Our Case Number: ABP-318704-23

Re: 10 year development of 9 Wind Turbines and associated infrastructure
at Borrisbeg and adjacent townlands, near Templemore town in Co. Tipperary
(<https://borrisbegplanning.com>)

Graffin
Clonmore,
Templemore,
Co. Tipperary
06th Feb 2024

Re: Observation to Strategic Infrastructure Development PA.318704 – Borrisbeg Renewable Energy Development in townlands of Borrisbeg, Eastwood, Ballycahill, Knockanroe, Clonmore, Graffin and Skehanagh, Co. Tipperary.

APPENDIX 12-5
WIND TURBINE NOISE
CONTOUR MAPS

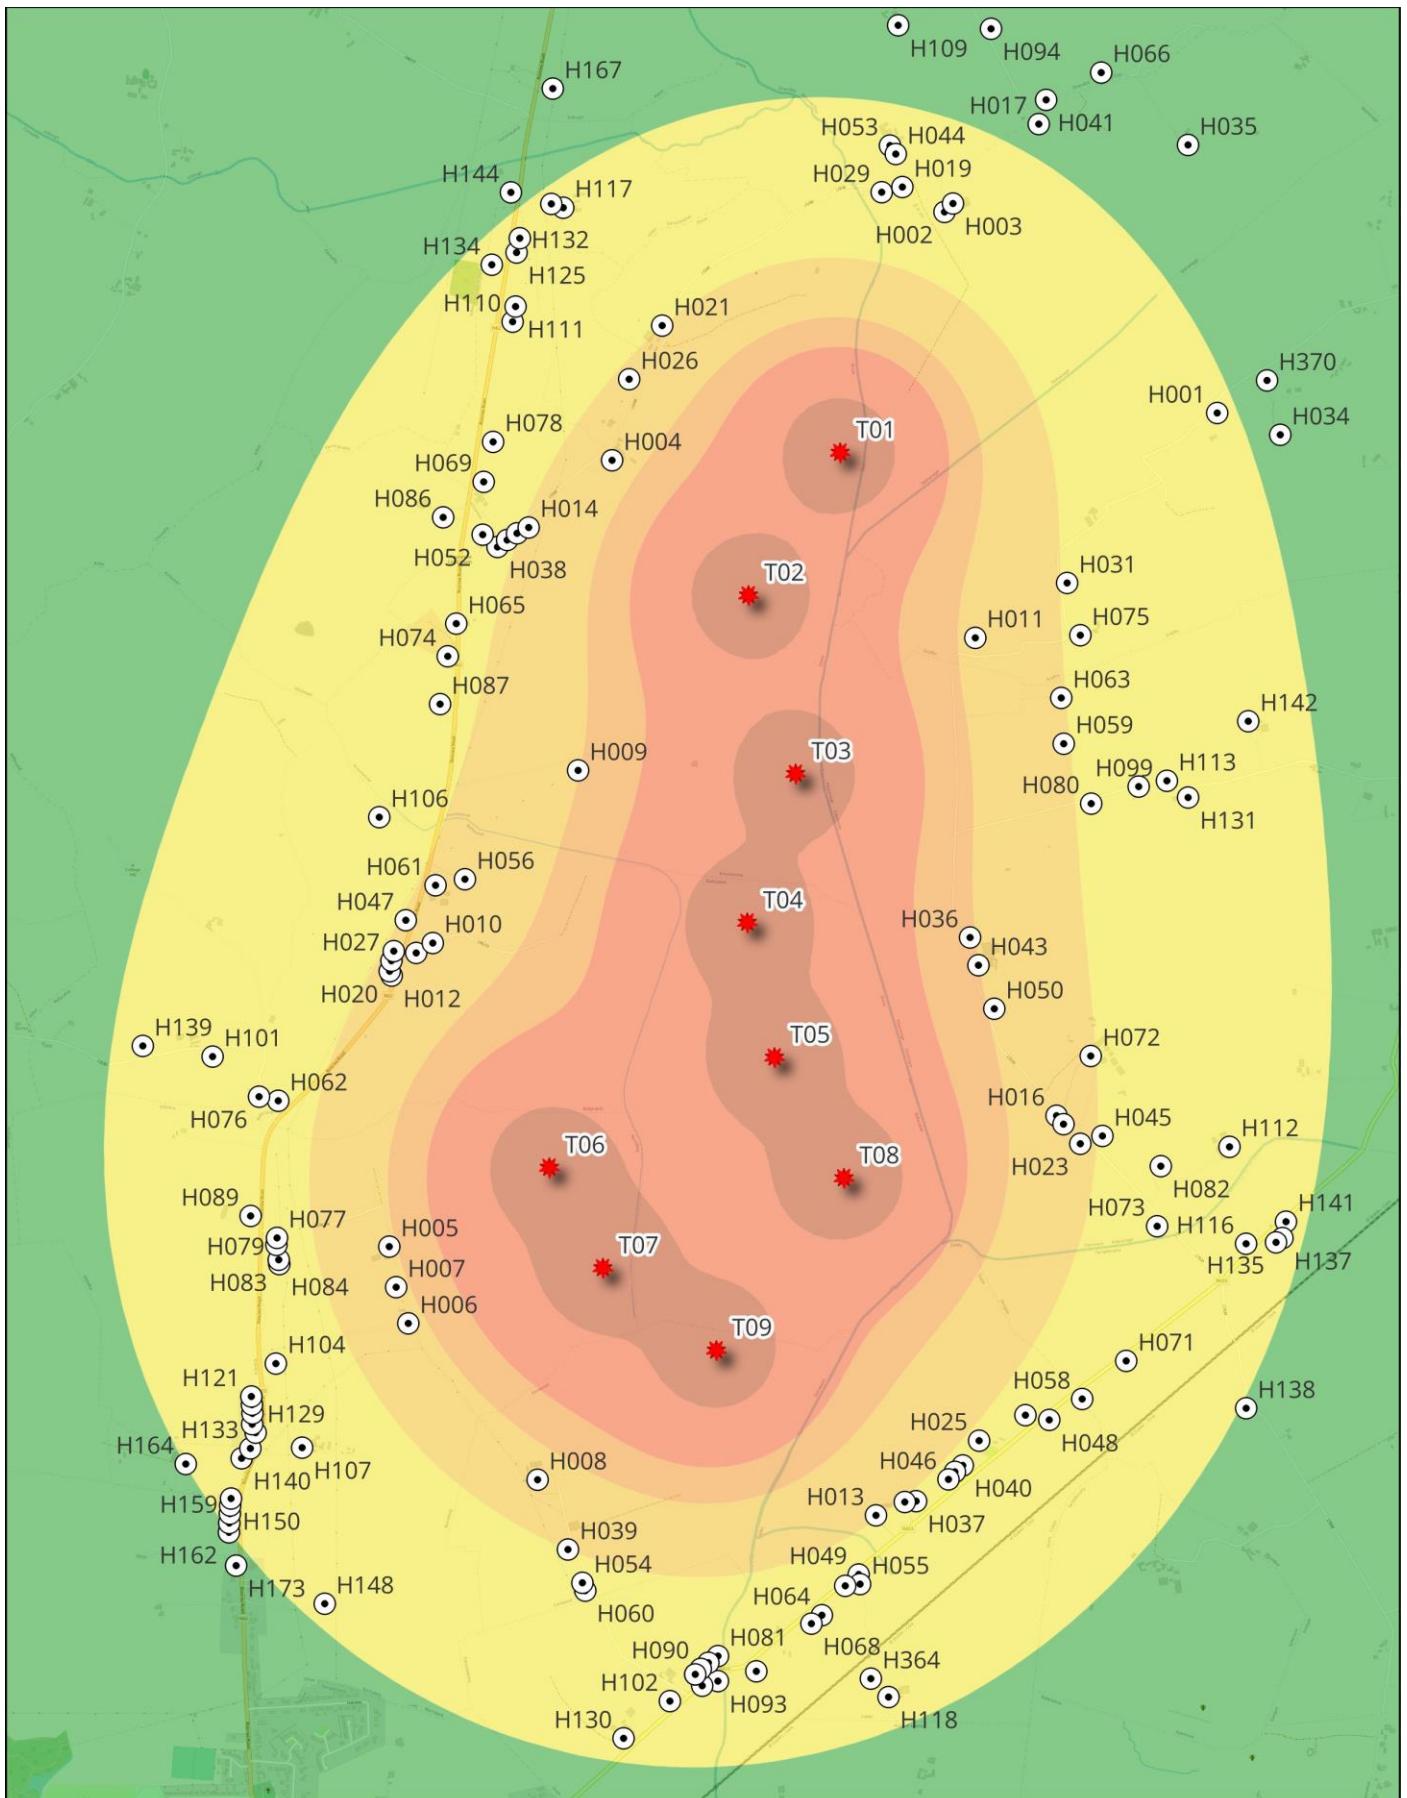
To provide context, our current home can be identified as **House H011** on *Appendix 12-5 – Wind Turbine Noise Contour Map of the EIAR*. This house commenced in 2020 and was completed in 2022. Our home is located approximately 700m northeast and downwind of the nearest wind turbine. Having reviewed the accompanying planning and environmental documentation, there are a number of aspects of the development proposal that remain of concern to both our residential amenity and the overall environmental integrity of the area.

Wind turbine noise is frequently pointed out as the reason for local communities' objection to the installation of wind farms. Our home, H011 in Appendix 12-5, is positioned directly northeast of T03 and T04. This house is identified in **Chapter 12, Table 12-20** as being located within the top 10 predicted noise levels at 8 m/s.

As previously stated, our property is located approximately 700m metres from the nearest turbine. In addition to this and given the prevailing wind in Ireland which will carry noise in the direction of the home, we remain deeply concerned that there is a very real risk of experiencing adverse noise impacts both inside and outside of our home.

We also note the operational noise daytime criterion differs per house with day-time noise criteria ranging from 40.0 – 45.0db for non-participating homeowners (e.g H011). However, such limits are increased to 45db for participating landowners. We respectfully suggest that a cautious approach should be taken to the relaxation of the guidelines and question if allowing such relaxation is appropriate if such houses are not guaranteed to remain within the ownership of the landowner for the duration of the operation of the wind farm. Furthermore, abandonment of property due to noise impacts would make for unnecessary dereliction and unsightliness in the countryside.
